Please ask for: Nicola Moore
Email: nicola.moore@arun.gov.uk
Telephone: Ext 37944
Our Ref: R/51/21/PDH
Your Ref:
Date: 16th March 2021

Prior Notification for a Permitted Development (Householder)

Development: single storey rear extension incorporating new open plan kitchen, dining area and lounge area, with bedroom extension.
Location: 28 Ash Lane Rustington BN16 3BT

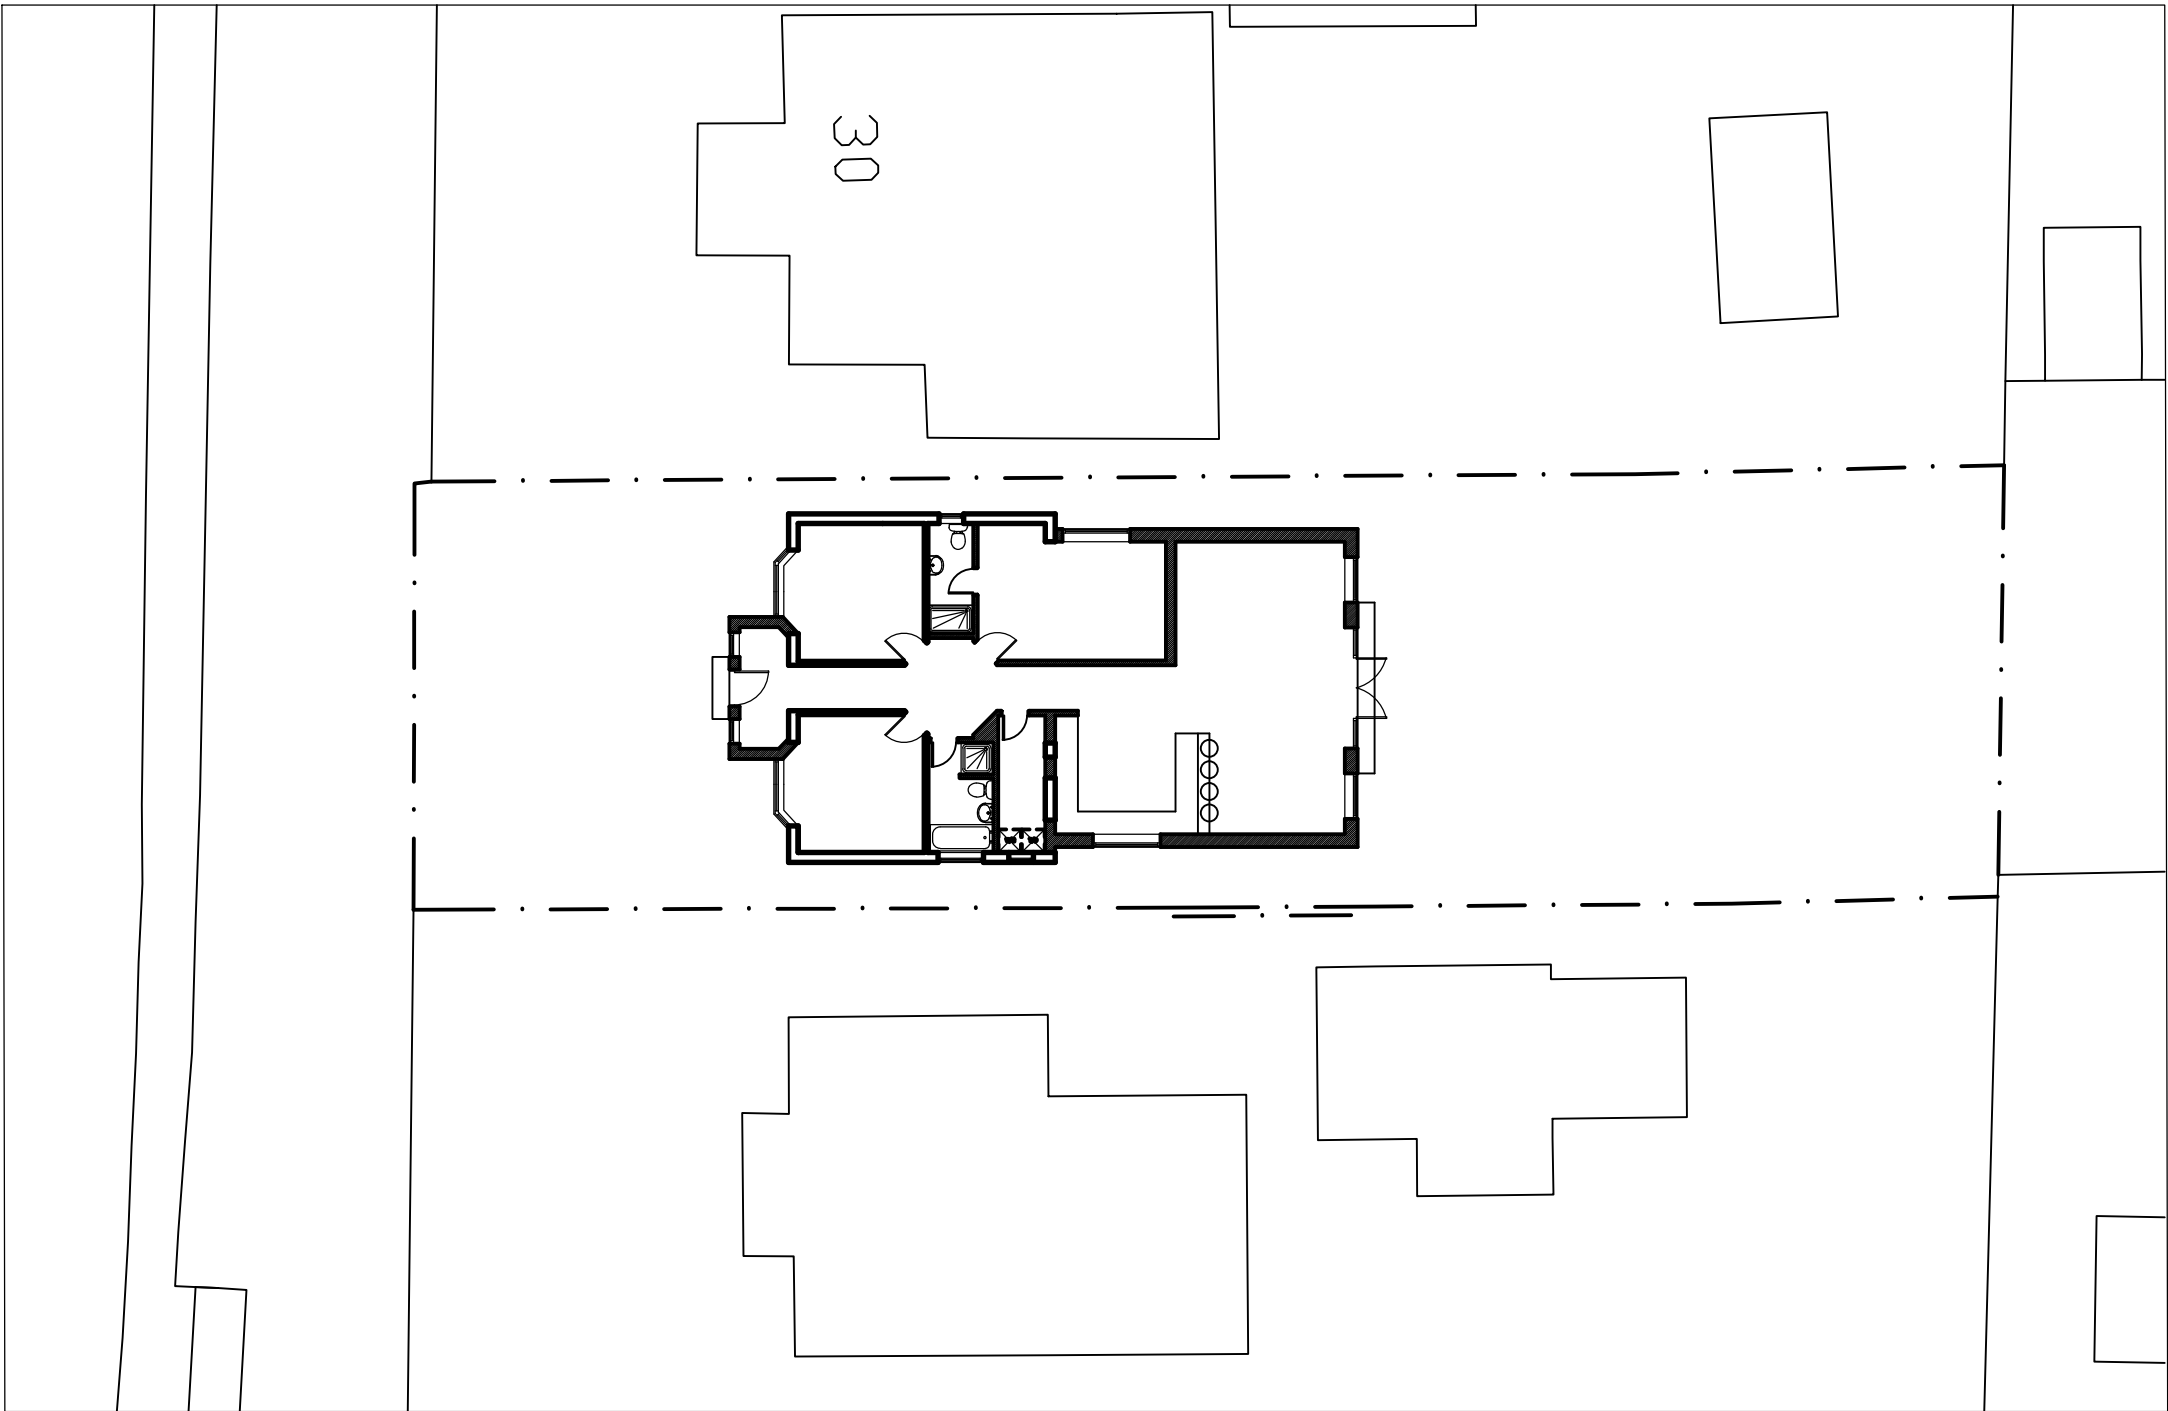
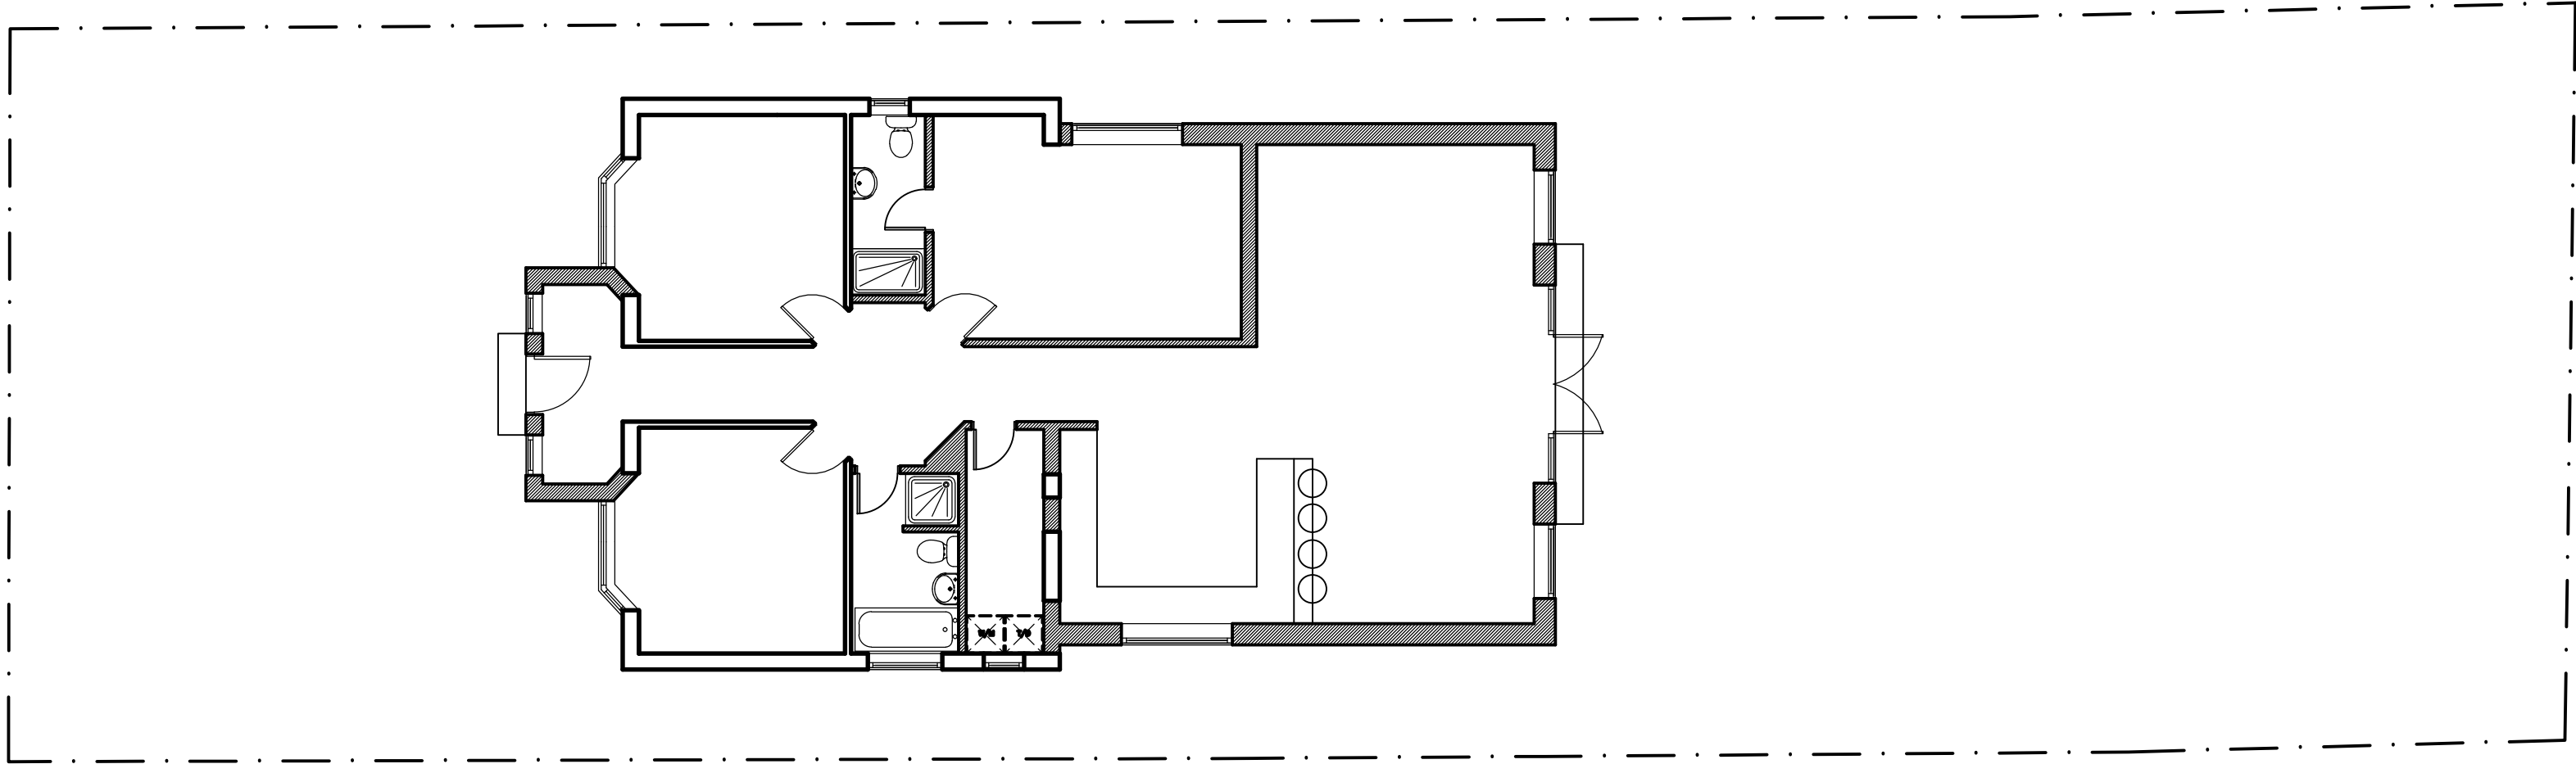
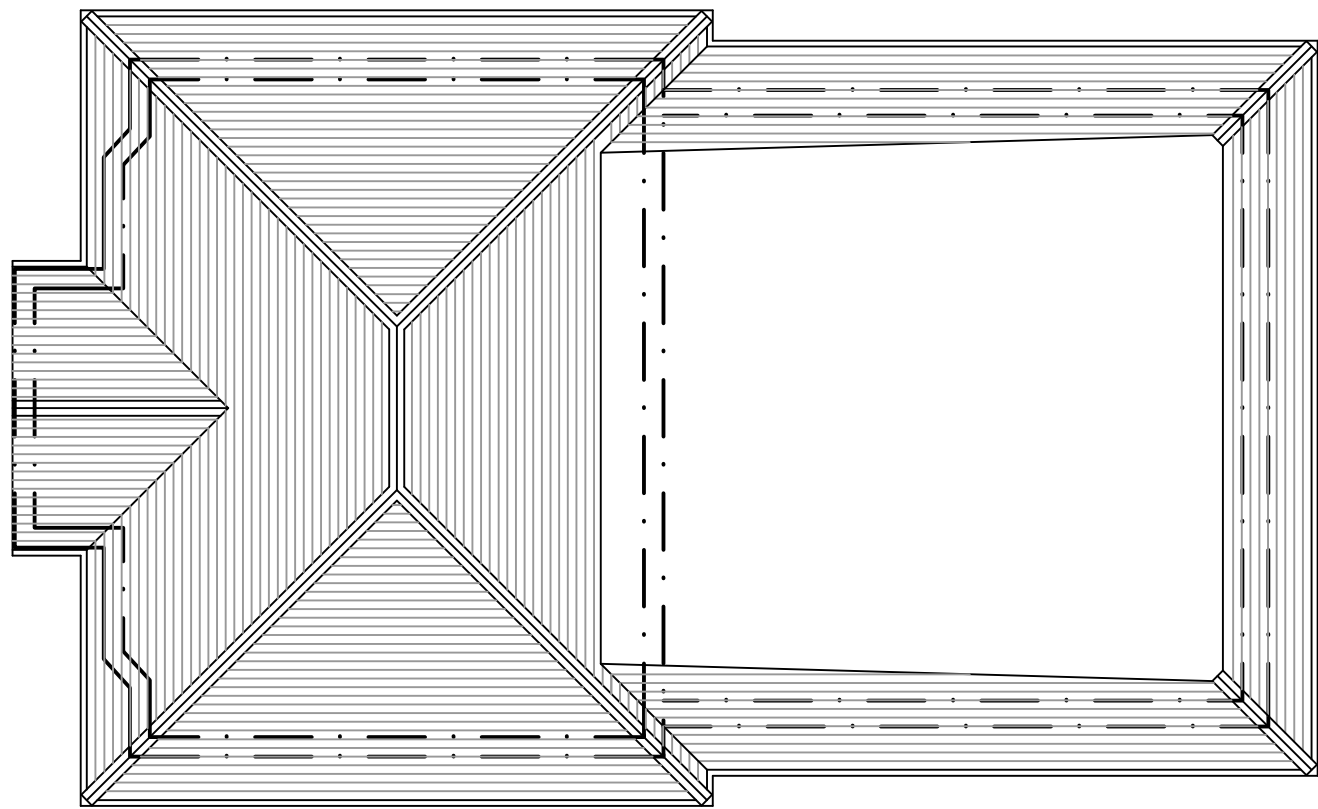
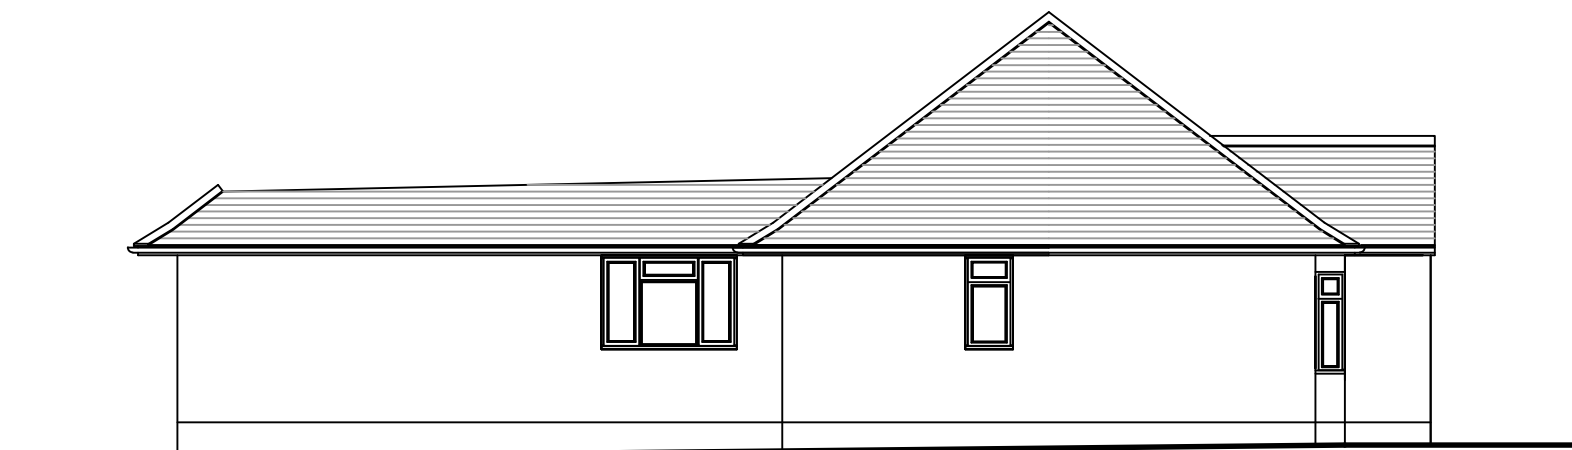
Both plans submitted are titled Plans & Elevations Existing. Please amend accordingly and re submit.
